**Subject:** Stormwater Comments Color  
**Page Index:** 1  
**Date:** 5/11/2021 7:51:09 PM  
**Author:** CFurchak  
**Color:** ■  
**Layer:**  
**Space:**  
**Page Label:** [1] 1 CV01

**NORTH SAND FILTER
EMERGENCY SPILLWAY**
SCALE: 1"=2'

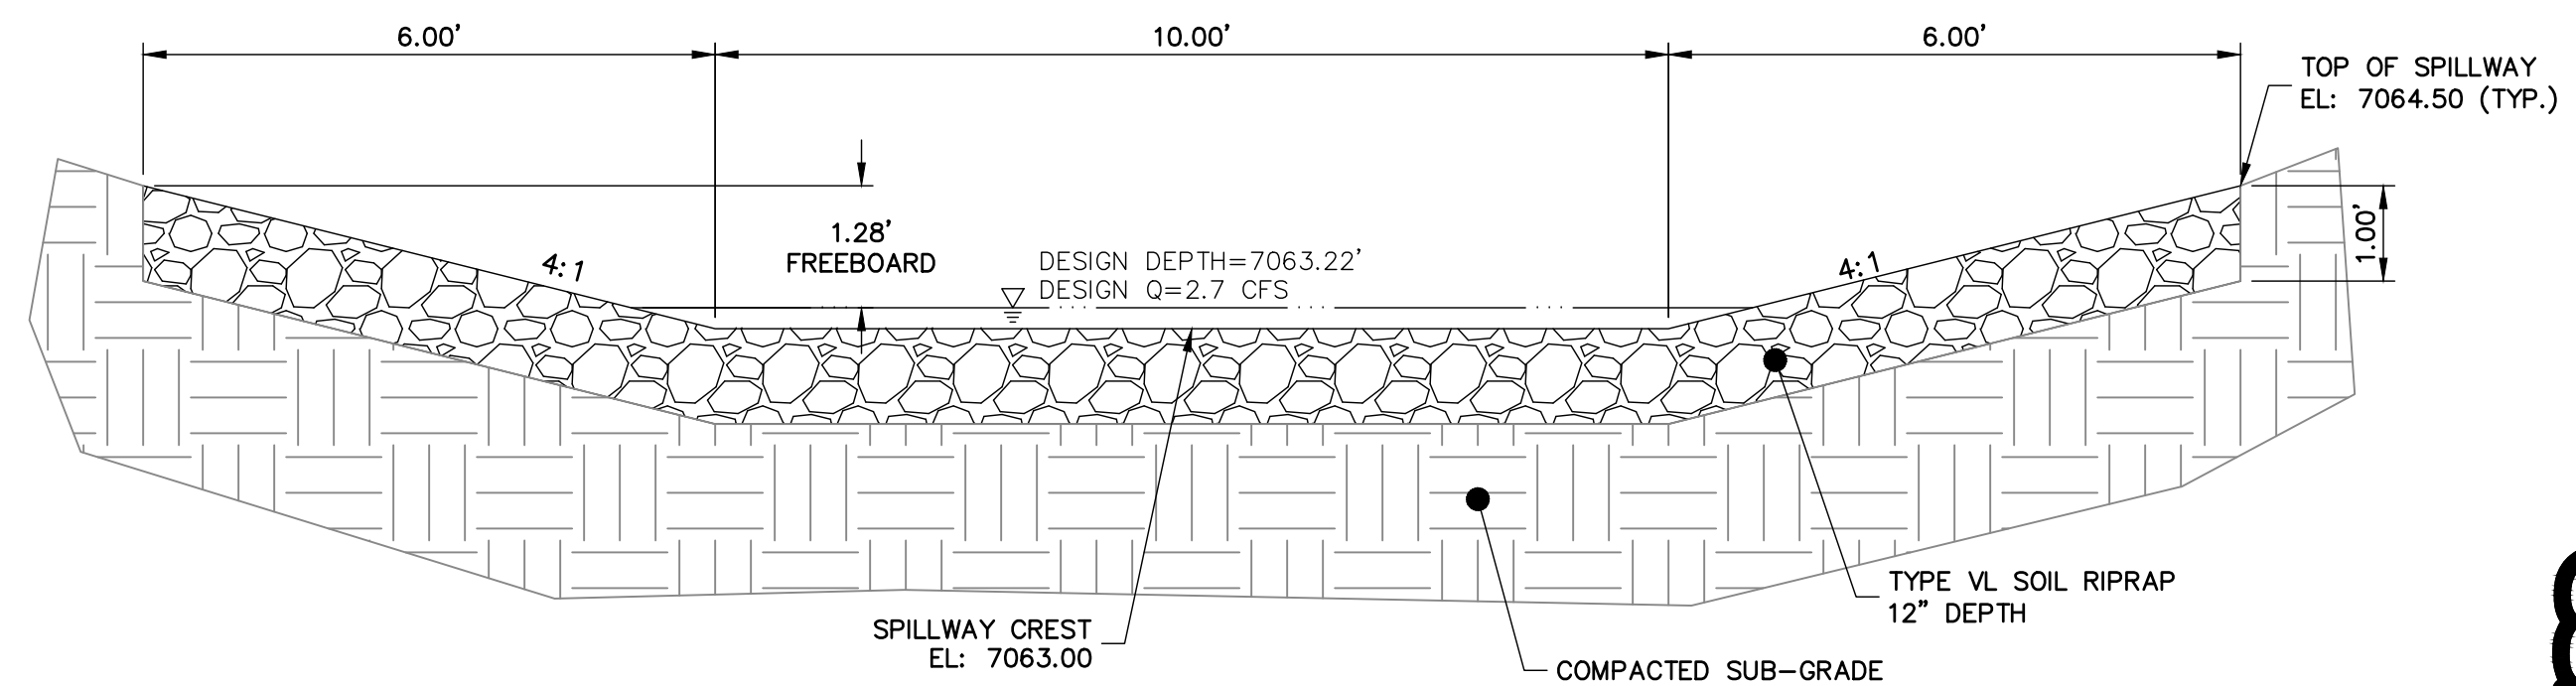
replace with EPC approved VTC detail (VT-1 and VT-2 in DCM Vol. 2, Chap 3.3) or revise to be 75ft min length

IPRAP Provide riprap gradation table and note that CDOT Section 506 Requirements apply

Provide riprap gradation table and note that CDOT Section 506 Requirements apply

provide gradation
